Rezoning Transportation Analysis

Petition Number: 2022-160

Date	Description
02-23-23	First Review (PDM)
03-23-23	Second Review (PDM)
04-25-23	Third Review (PDM)

RZ1.00

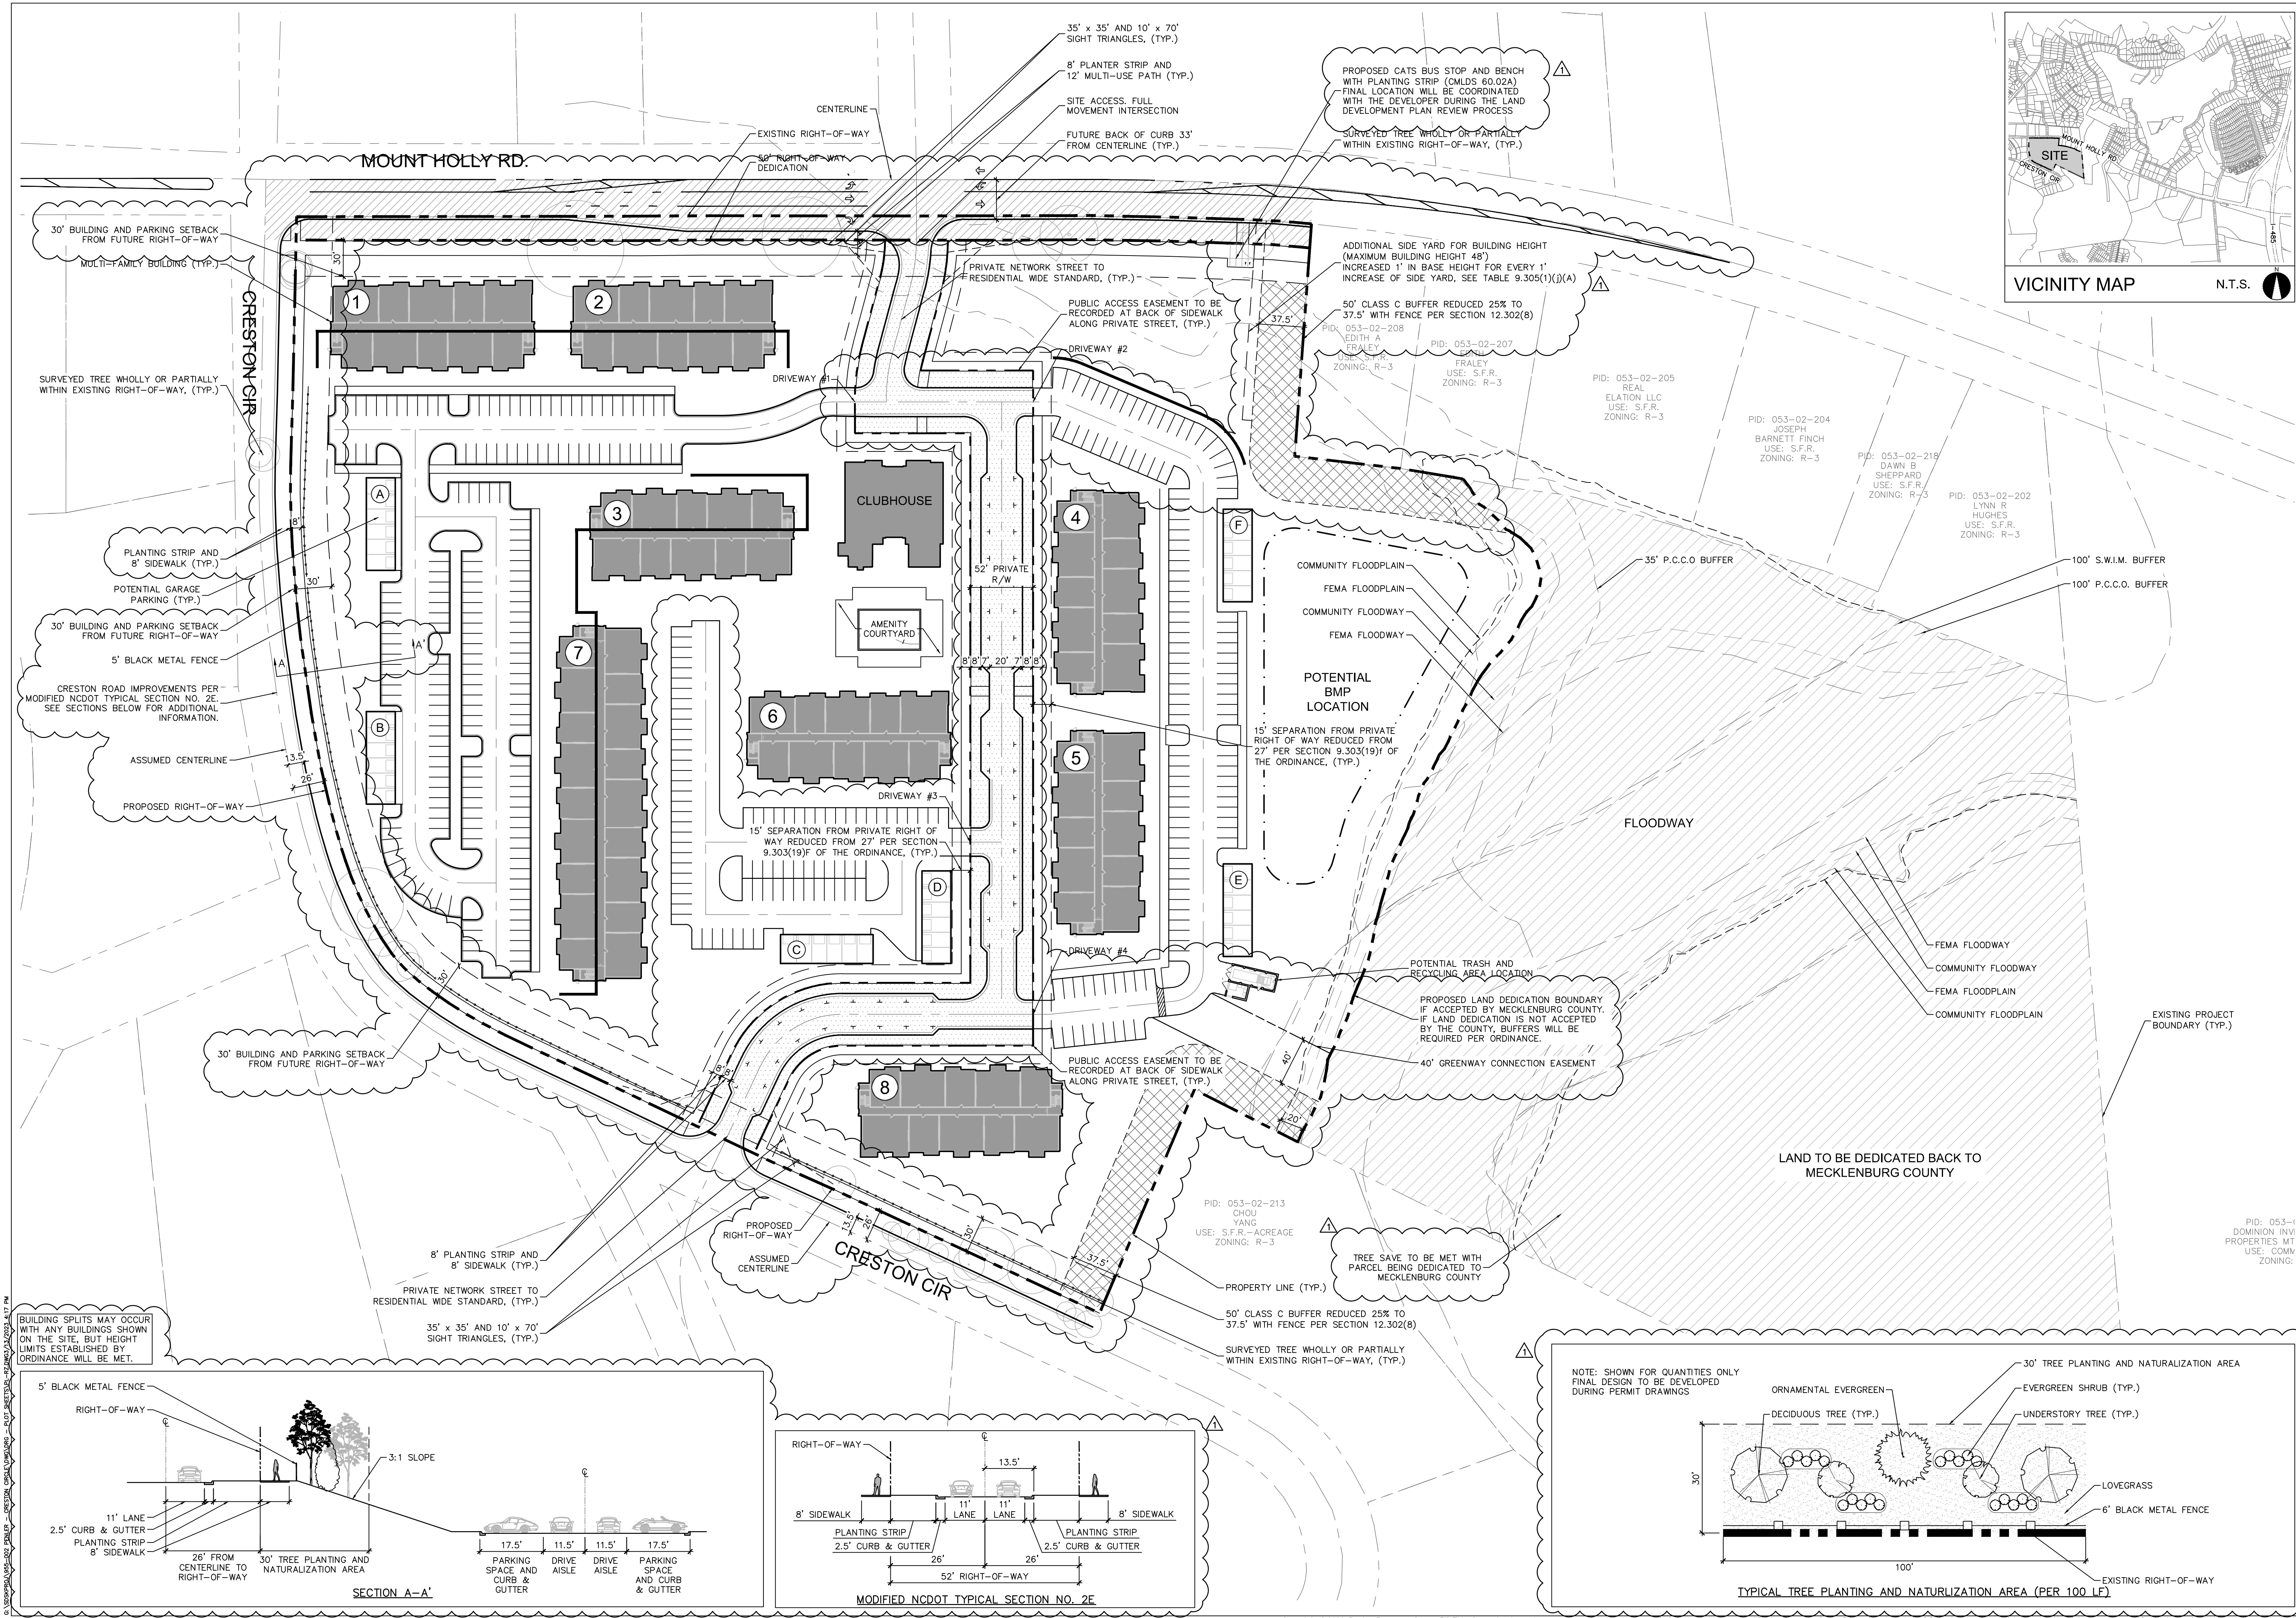
- a. ~~Mount Holly Road:~~ Location of curb and gutter to be installed at 33 feet from roadway centerline to accommodate the Charlotte Streets Map roadway typical section of a four plus lane avenue with shared use path.
~~UPDATED COMMENT 3.23.2023:~~ Future back of curb needs to be show at 33ft for entire Mount Holly Road frontage for planning purposes.

Label and dimension the curb and gutter from the centerline for each road on the site plan.

UPDATED COMMENT 3-23-2023: Revise cross section to CLDSM U-03 for Local Residential Wide.

UPDATED COMMENT 4.25.2023: Update proposed note to include buildings 4-8. Creston Road improvements need to be completed prior to first CO for the site, or a more balanced phasing plan needs to be proposed. The current proposed phasing based on CO for building 4 leaves too much public infrastructure work outstanding for the last building if buildings are not constructed in sequence, and it is not proportional. In addition, Creston Circle improvements should be completed prior to access to Creston Circle is permitted.
